**PREFERRED PROJECT REPORT
MP 08_0258**

61 MOBBS LANE, EPPING

APRIL 2010

A1

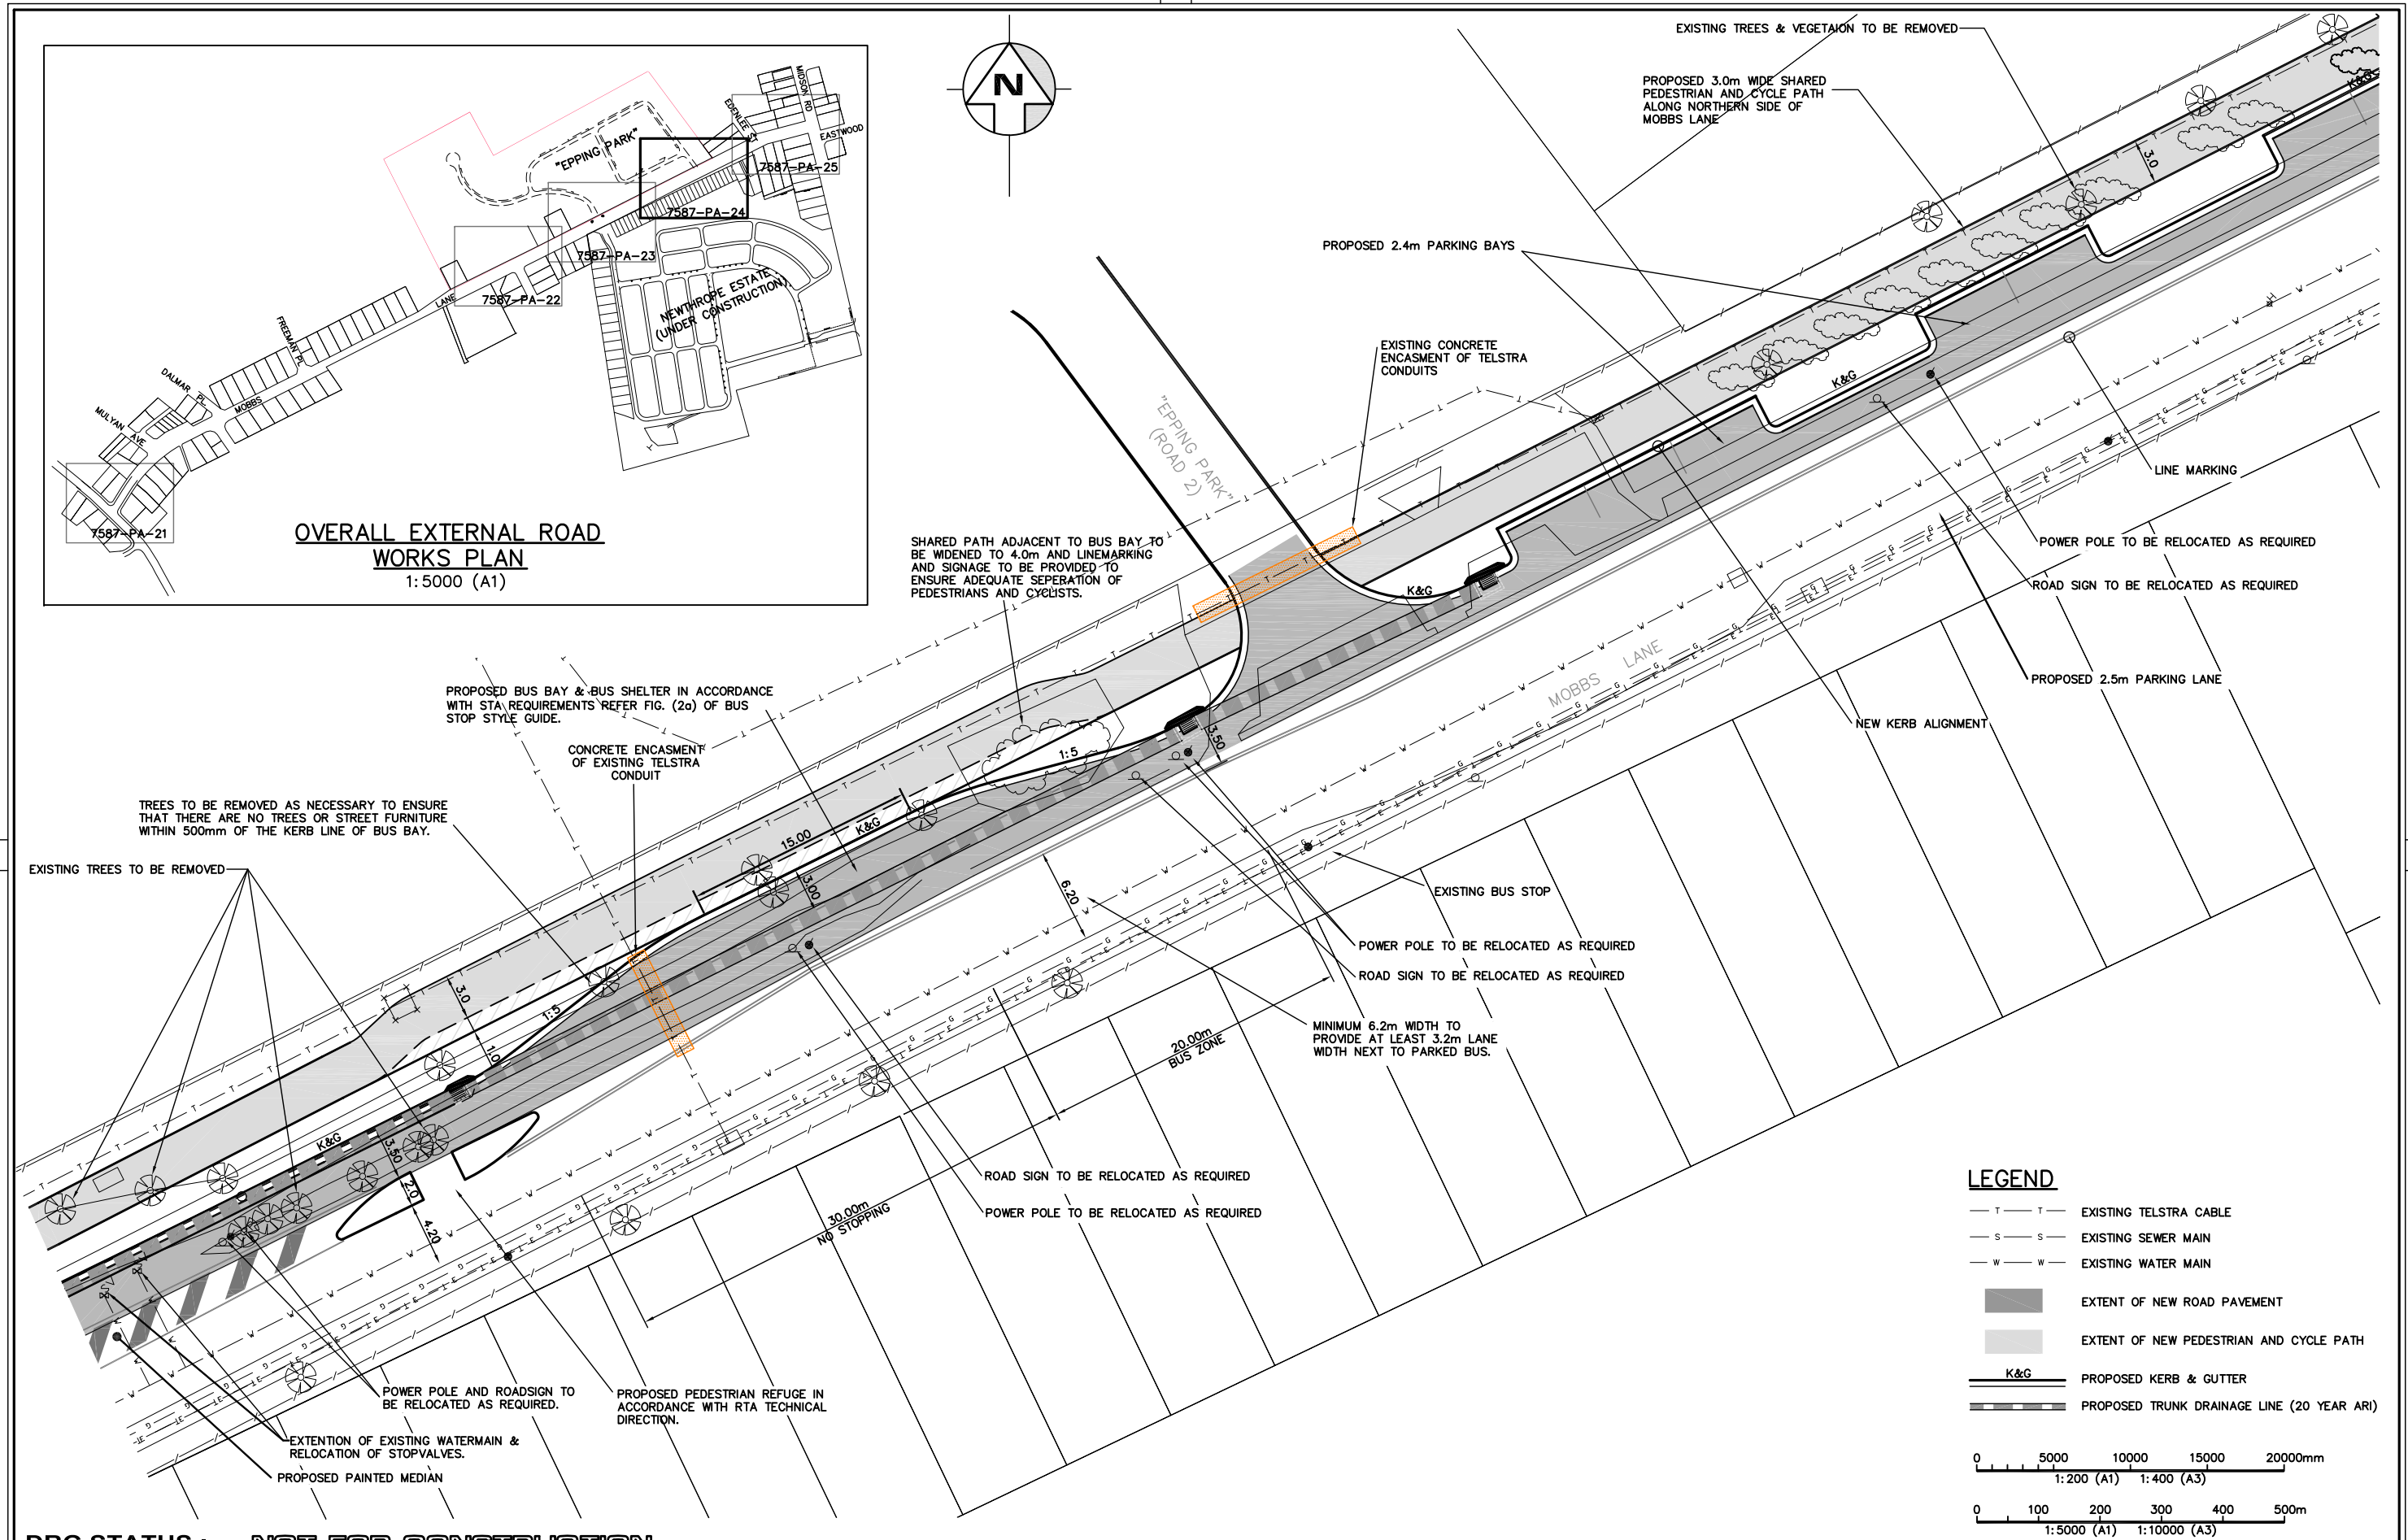
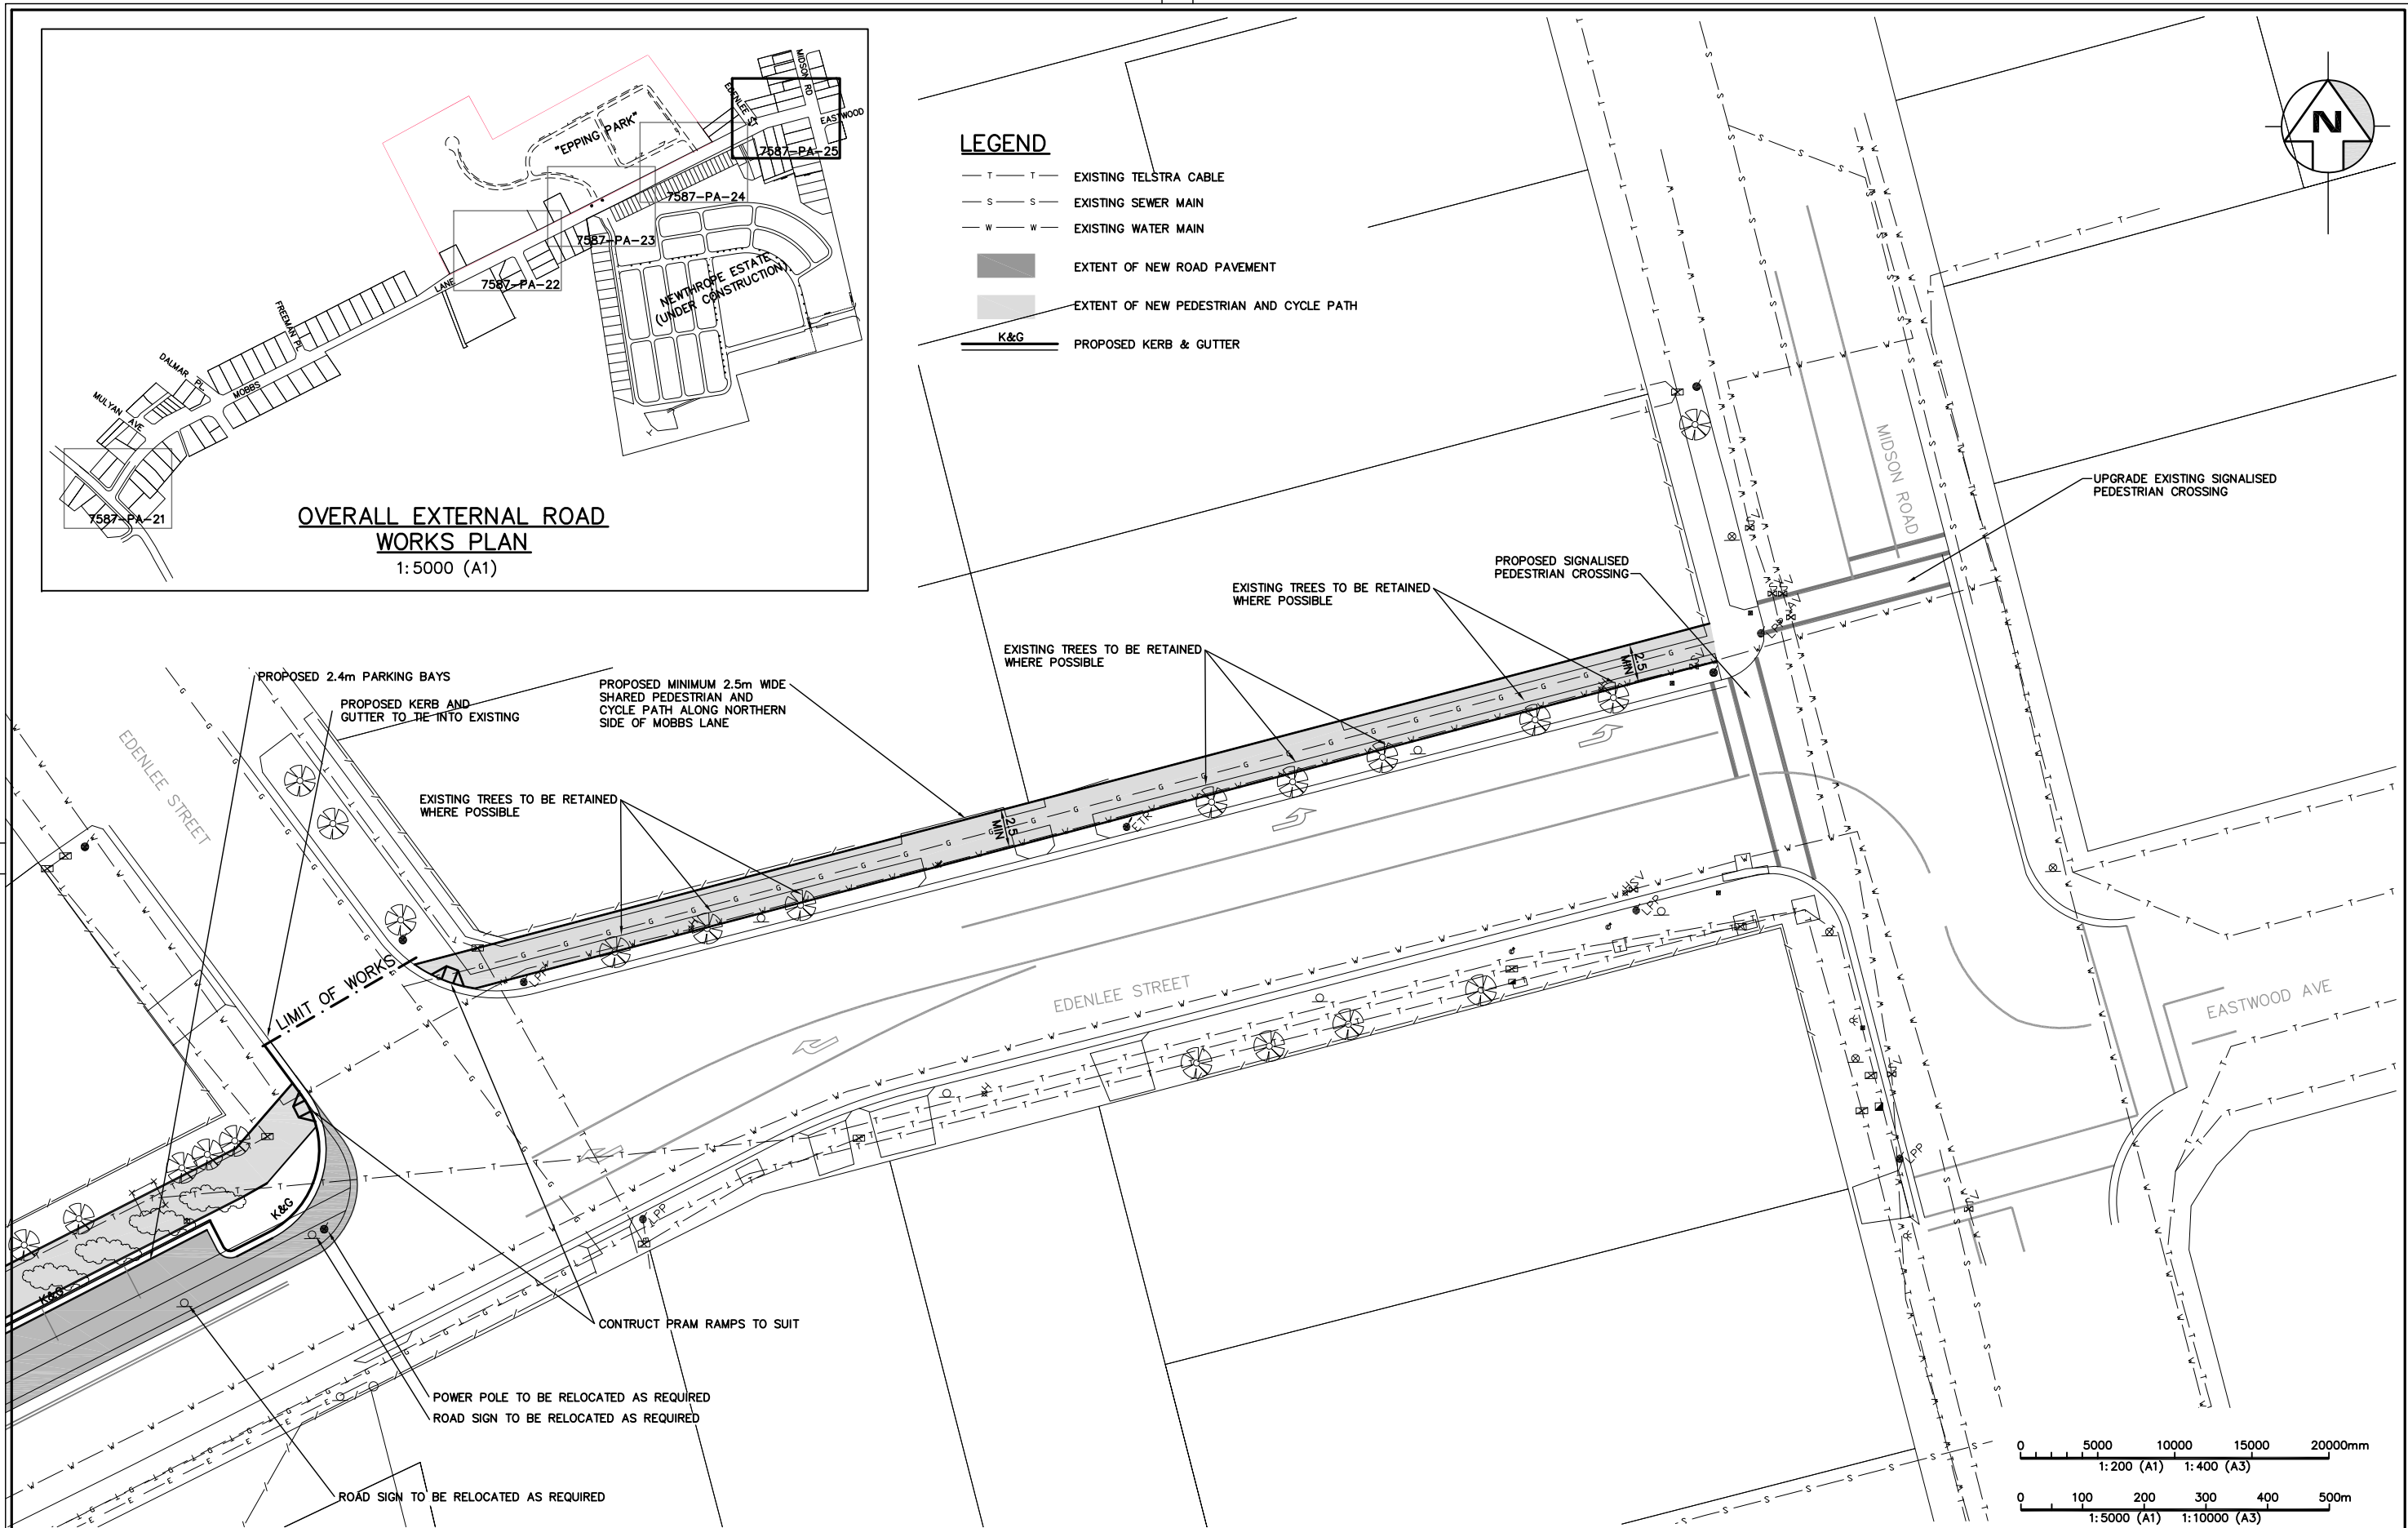
Drawing No. 7587-PA-22 to 25

The matters raised under this heading of Council's submission can be imposed as a condition on the approval. This would apply to proposed Stage 3 of the development.
